#### Valley View

9368 Valley View Drive NW  
Traffic Circulation Layout

### Response to review dated July 9, 2021

1 Site Plan - Proposed
Scale: 1" = 20'-0"

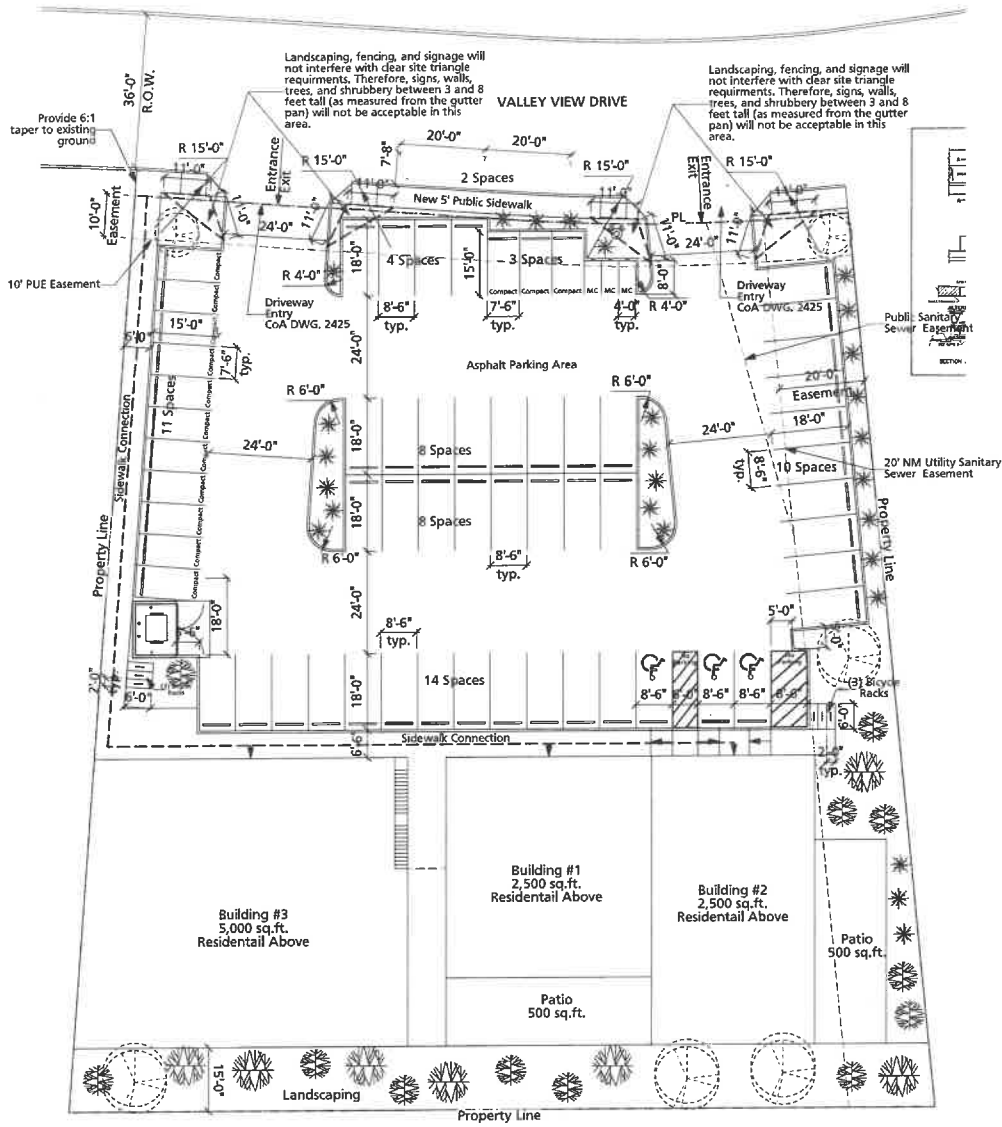
1. Not sure what this note is referring to: Number of spaces is per IDO
2. Corrected- internal C&G only
3. Added
4. Corrected
5. They are
6. They are
7. They sidewalk ramps are part of CoA std. dwg 2425 (noted on plan)  
Dimensions added and graphic changed to reflect dwg 2425

8. See drawing
9. See #5 detail
10. See drawing
11. See drawing
12. See Fire-1 Attached
13. All keyways are 5' min.
14. See sidewalk connection - exact entrances to buildings has not been  
designed- the entire frontage is accessible.

15. Ramps will be part of sidewalk from Accessible Aisle
16. There are no Vehicle to wheel chair conflict-
17. Sidewalk is on property line / noted / noted on detail #2

18. Added Bumpers-  
per IDO 7-%(k)(4)5. Vehicles may overhang walkways and  
landscape areas as long as the over- hang does not  
negatively impact the proposed landscape or reduce the  
required pedestrian access route to less than 4 feet wide.

19. Attached
20. Asphalt Parking Area called out on plan
21. Driveway Entrance Called out- not sure where else you need them
22. Mini Work Order
23. Noted
24. Noted

25. Noted
26. -
27. see attached
